## WEST SUSSEX COUNTY COUNCIL CONSULTATION

| <b>LOCATION:</b>                | Land at rear of Cedar End<br>Eastergate Lane<br>Eastergate<br>PO20 3SJ                                                                                                                                                                                                   |
| <b>SUBJECT:</b>                 | BN/65/22/PL<br><br>Sever land and erection of 1 No bungalow with new vehicular access (resubmission of BN/14/22/PL). This application is a Departure from the Development Plan and is in CIL Zone 3 and is CIL Liable as new dwelling.<br><br>More information received. |

Proposed Site Plan
1:200

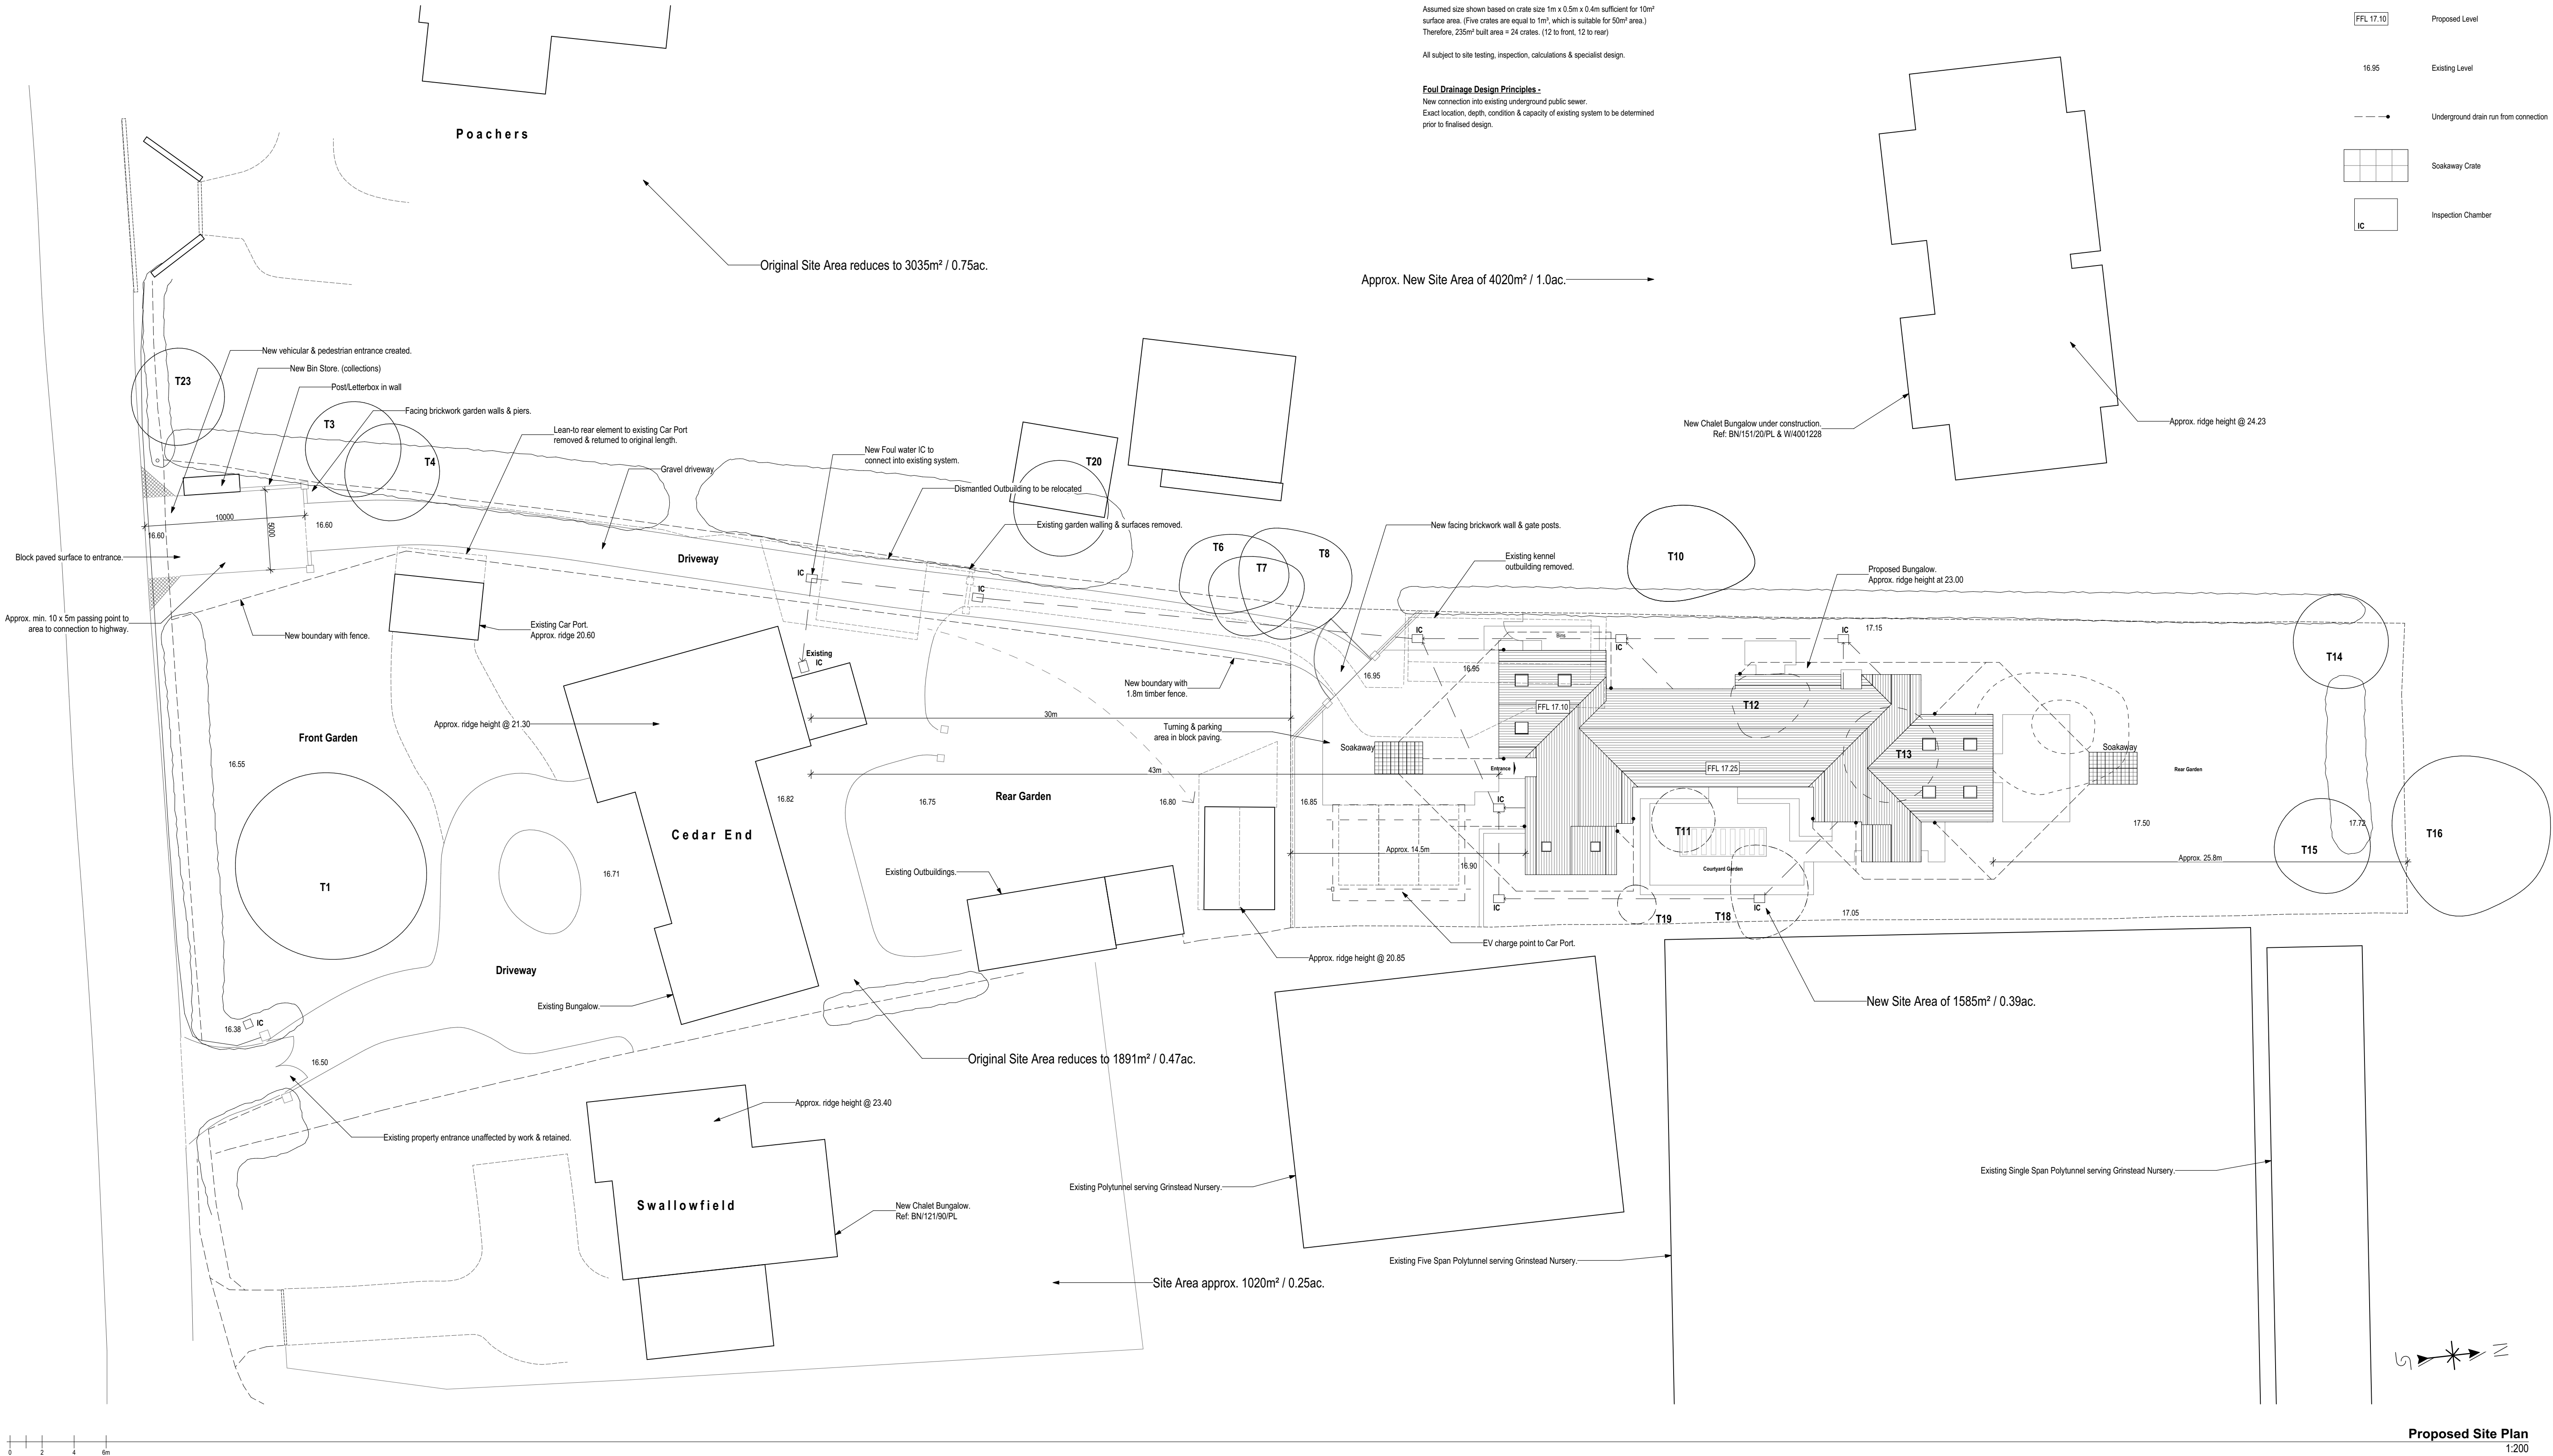
The applicant proposes to implement a new 9 metre (Kerbside) VCO access.

The applicant should be made aware that VCO's under 4.5 metres or over 6.4 metres are generally not accepted at the licensing stage. Though in this instance, such a provision is not considered a highway safety concern. The applicant should be mindful that this may result in, if successful, a planning permission that cannot be implemented. Therefore, the applicant is recommended amending the plans to show a kerbside VCO of between 4.5 – 6.4 metres. Details of which can be secured via a suitably worded condition.

The applicant has provided parking for 3 spaces plus garage space and an area for turning. The LHA believes this provision to be adequate.

No part of the development shall first be occupied until such time as the vehicular access has been constructed in accordance with plans and details **to be** submitted to and approved in writing by the Local Planning Authority.

No part of the development shall be first occupied until the car parking has been constructed in accordance with the approved site plan. These spaces shall always thereafter be kept for their designated purpose.

Visibility Splays
1:2000

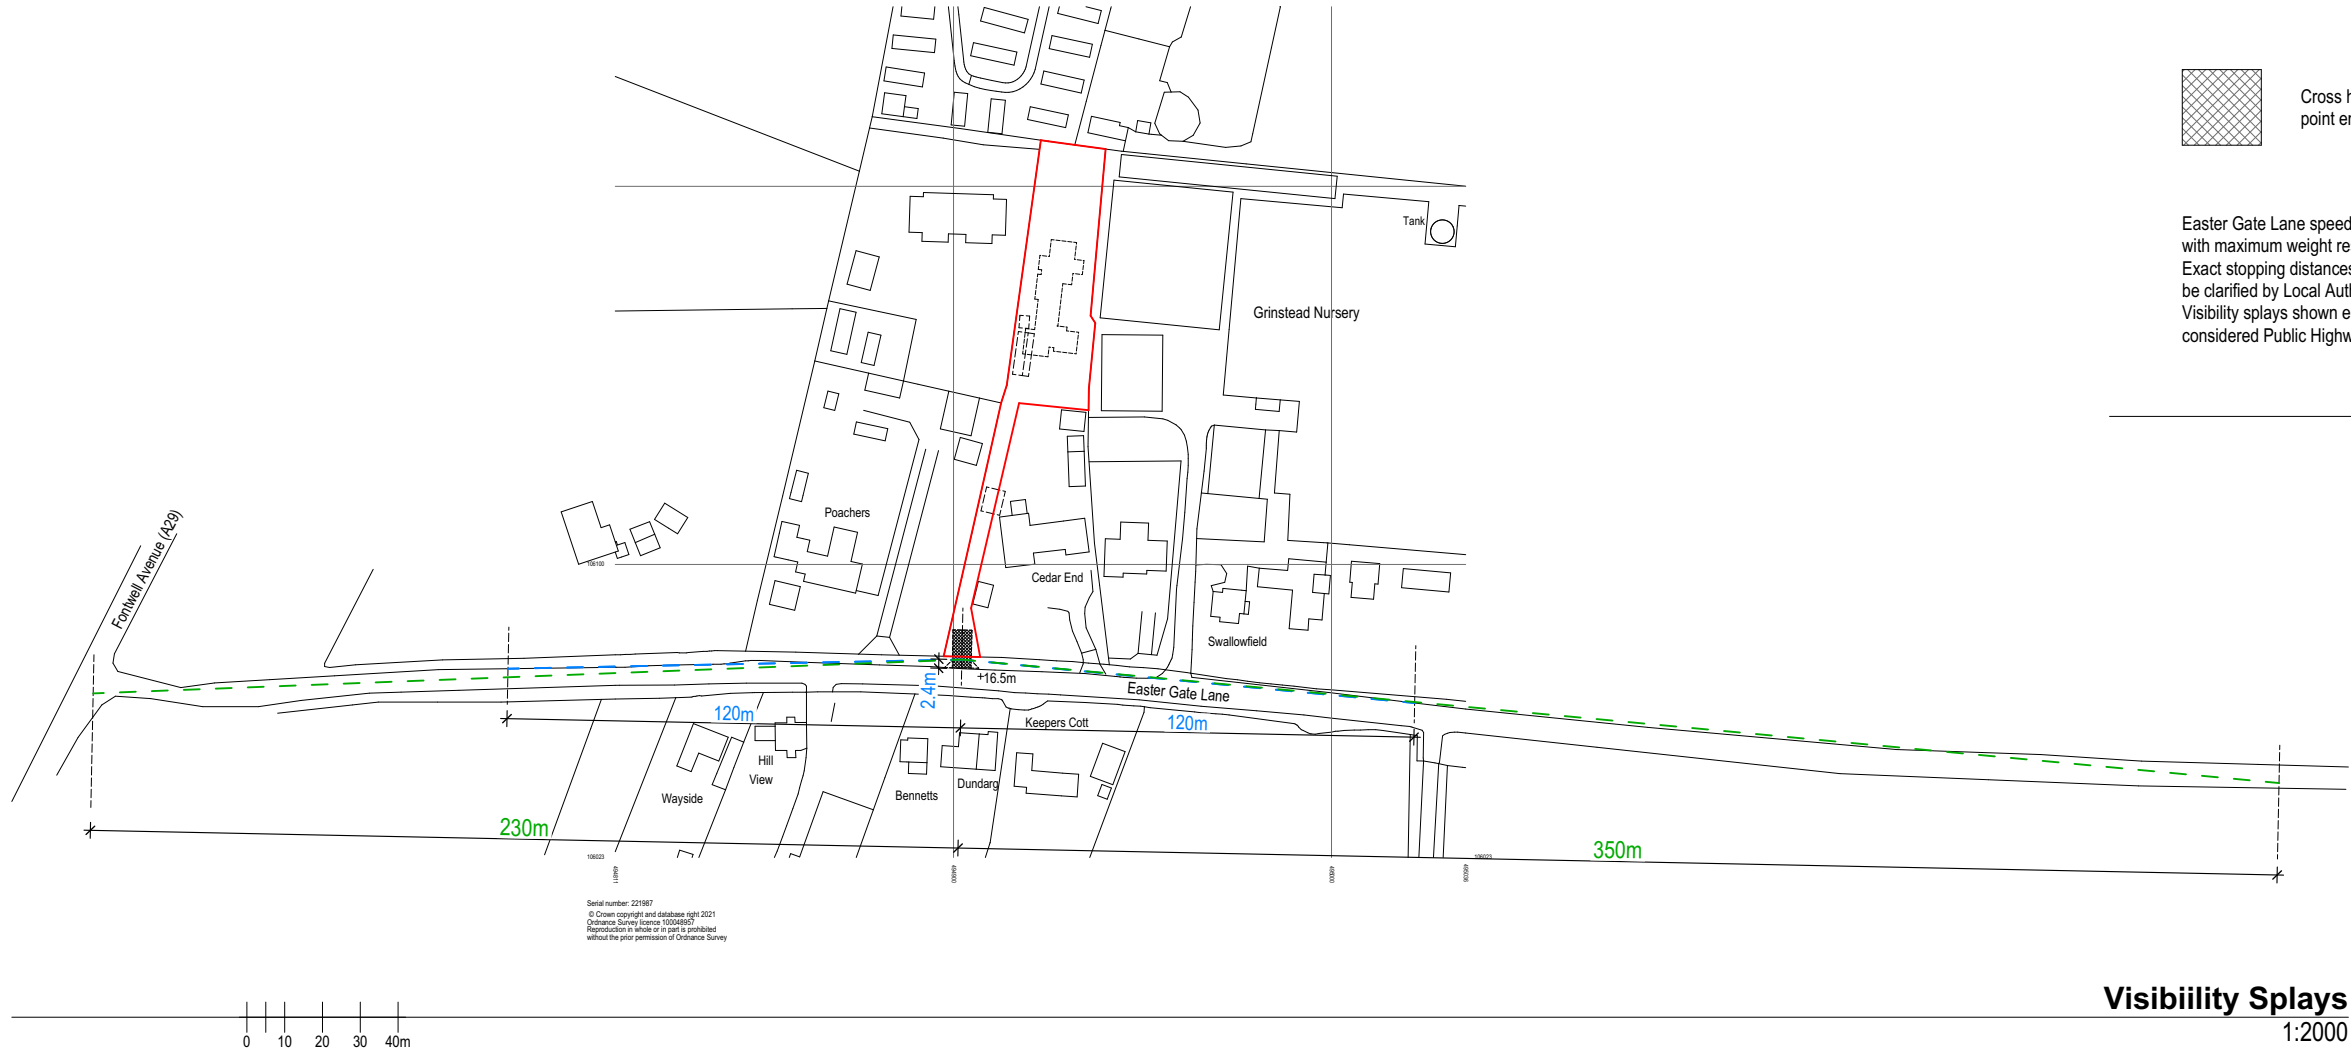
The applicant has provided visibility of 2.4 x 205 metres (Eastbound) and 2.4 x 260 metres (Westbound). These visibility splays are appropriate for road speeds up to 60 mph.

The use of the access shall not commence until visibility splays of 2.4 x 205 metres (Eastbound) and 2.4 x 260 metres (Westbound) have been provided at the proposed site vehicular access onto Eastergate Lane in accordance with plans and details submitted to the Local Planning Authority. The splays shall be maintained and kept free of all obstructions over a height of 0.6 metre above adjoining carriageway level or as otherwise agreed.
